Application Reference: 6/2022/1084/COND

Proposed development at: Campus West The Campus Welwyn Garden City AL8 6BX

Proposal: Submission of details pursuant to condition 9 (sustainable energy) ,10 (car charging points) ,11 (CCTV) ,12 (privacy screens) ,13 (landscaping) and 14 (materials) on planning permission 6/2021/2207/MAJ

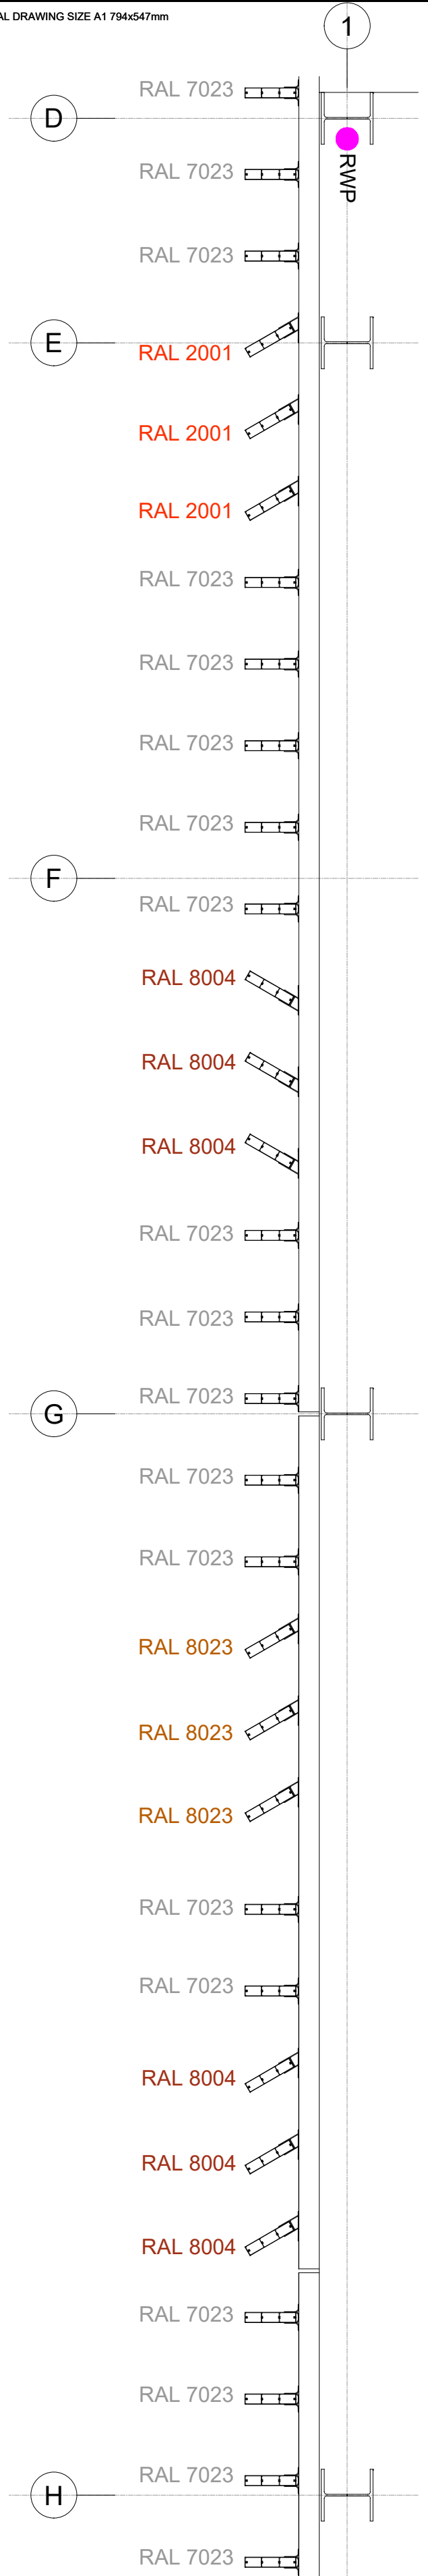
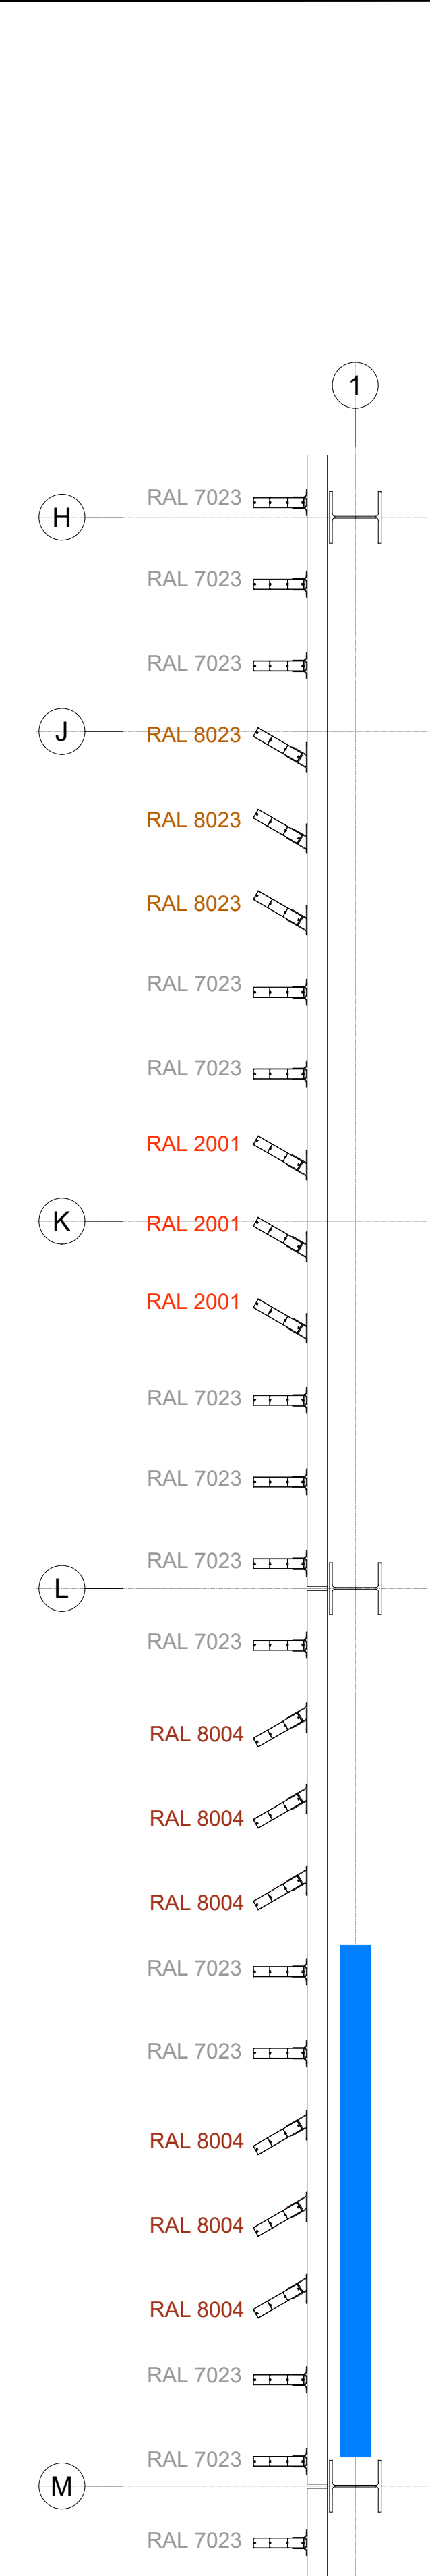
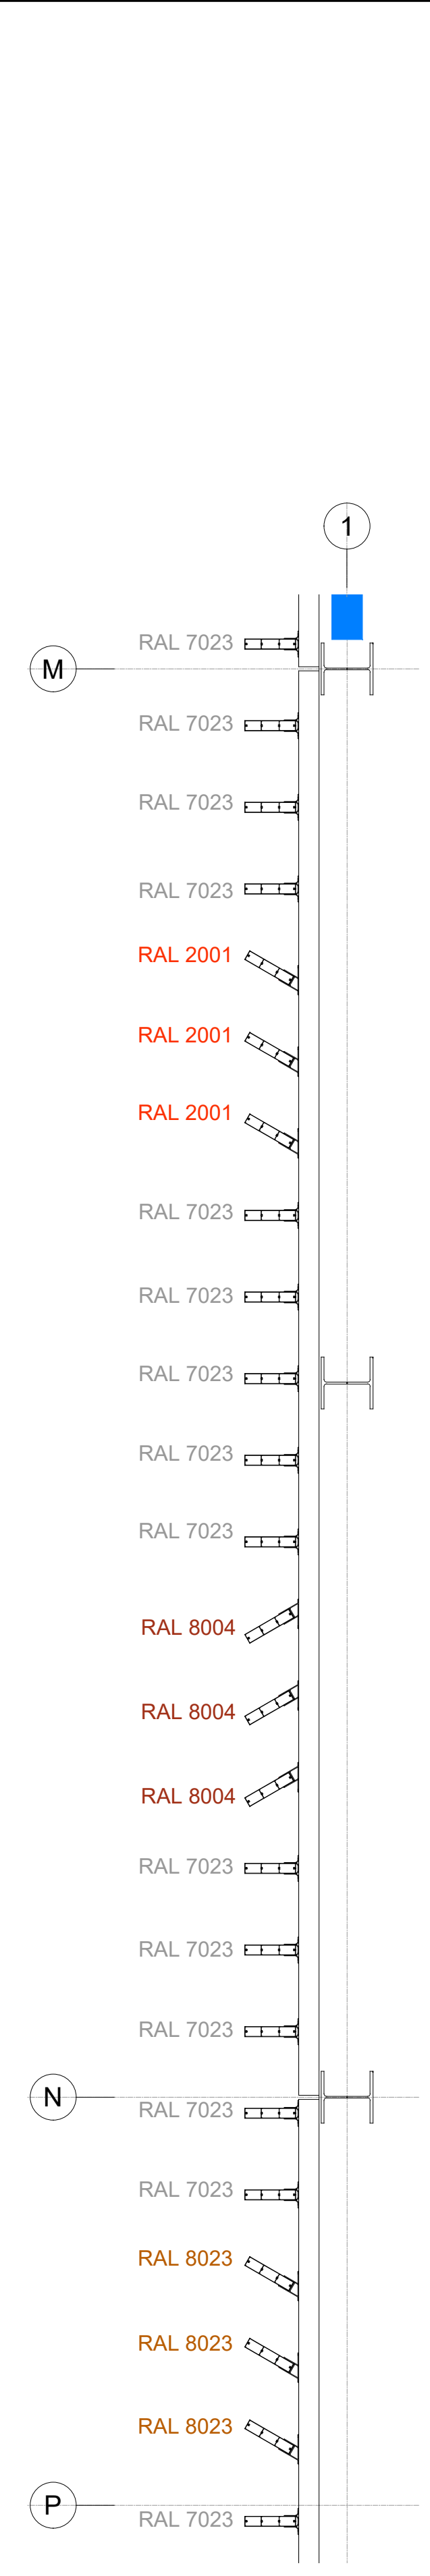
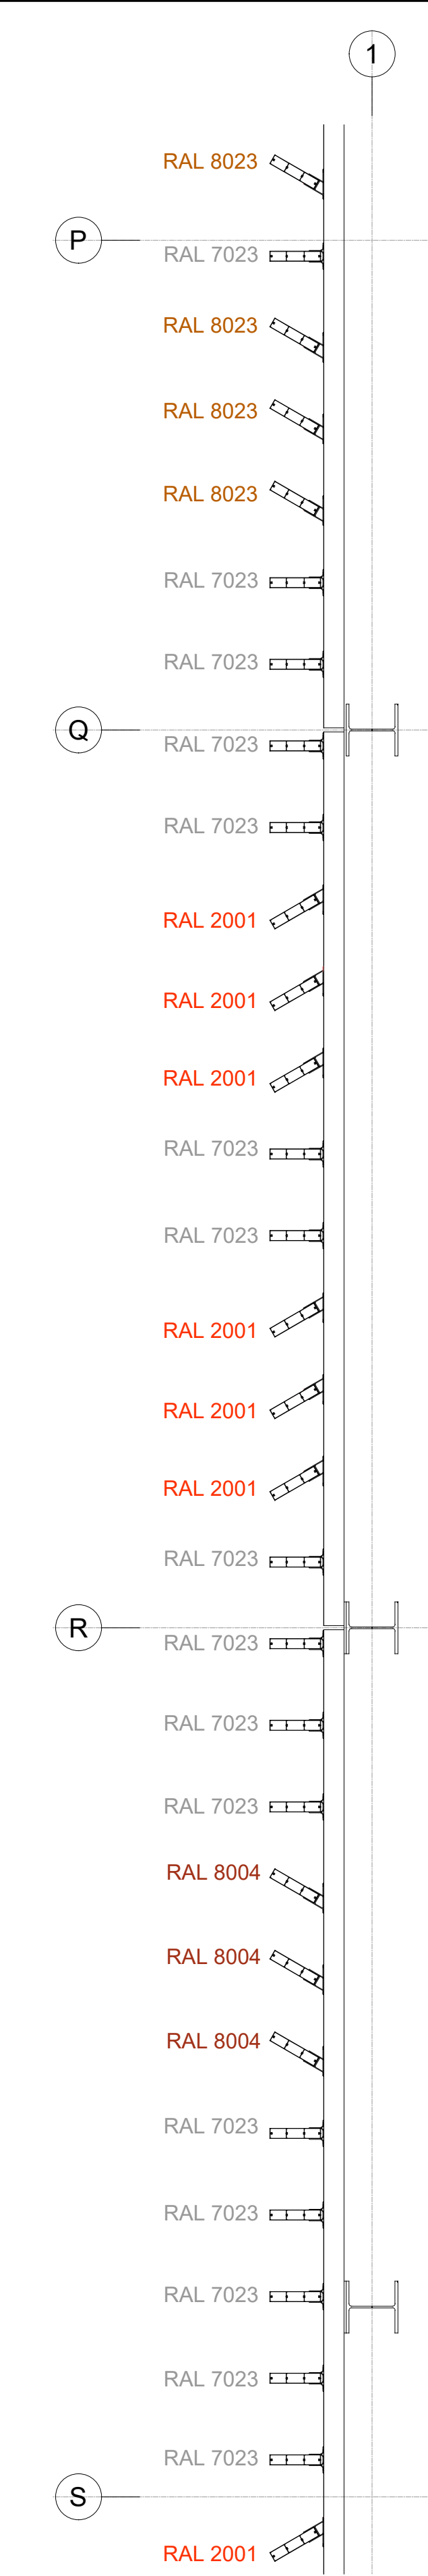
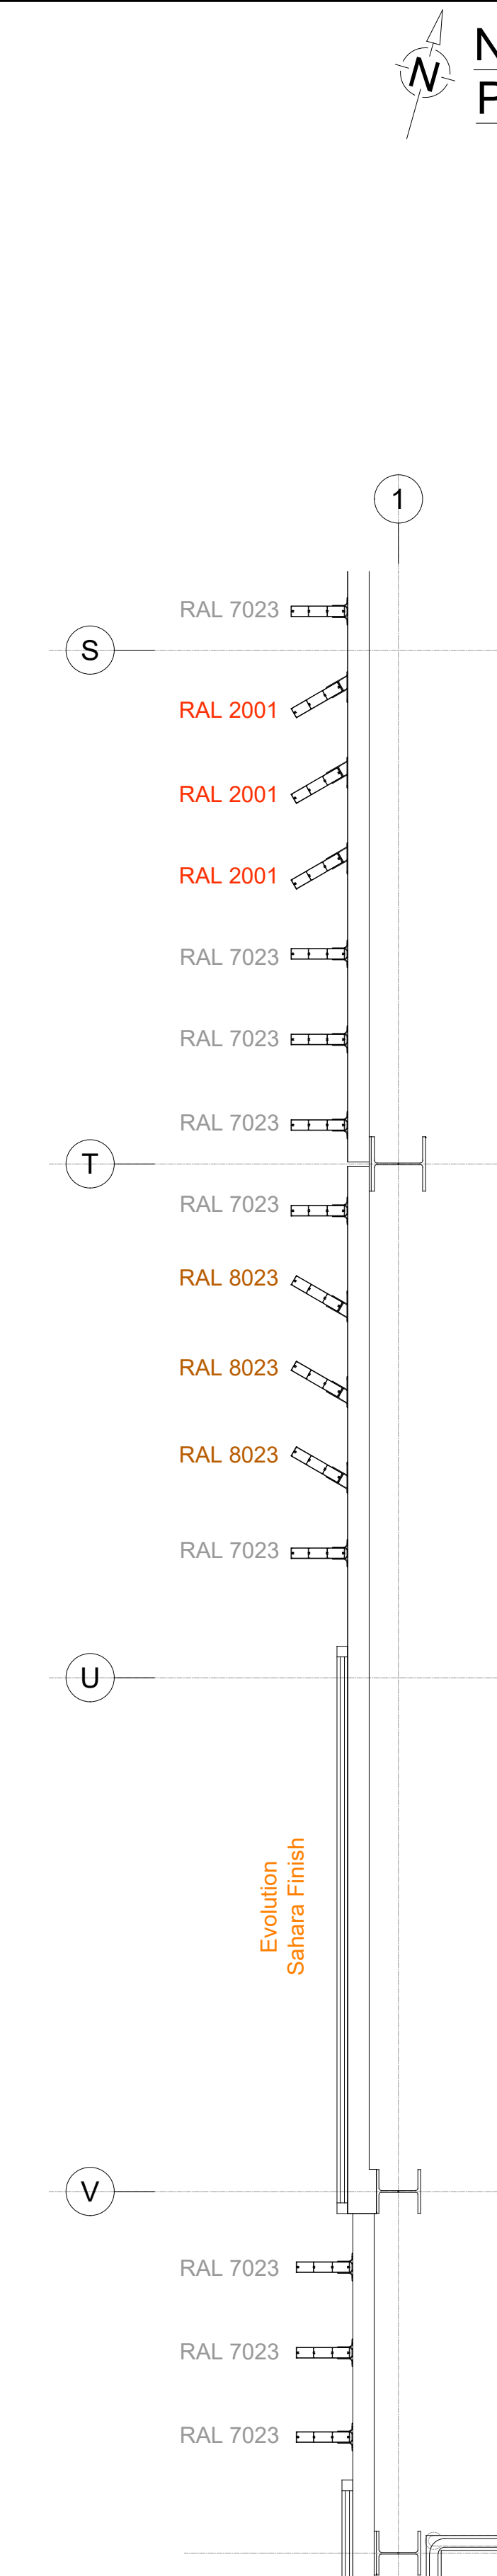
Material samples of the Cladding Panel (Corten), Cladding Fin & Privacy Screen / Headlight Screen have been provided for inspection. Furthermore, detailed drawings of the cladding arrangement have also been provided showing each fin and panel location on the building along with the proposed colours which consists of a mixture of RAL 7023, RAL 8023, RAL 8004 & RAL 2001. The Conservation Officer was consulted on the application and no objections were raised to the submitted details. I can therefore confirm that sufficient information has been submitted pursuant to the requirements of condition 14 and the proposed materials are considered to be acceptable. In order to fully comply with the requirements of condition 14, the development shall be implemented using the approved materials and subsequently, the approved materials shall not be changed.
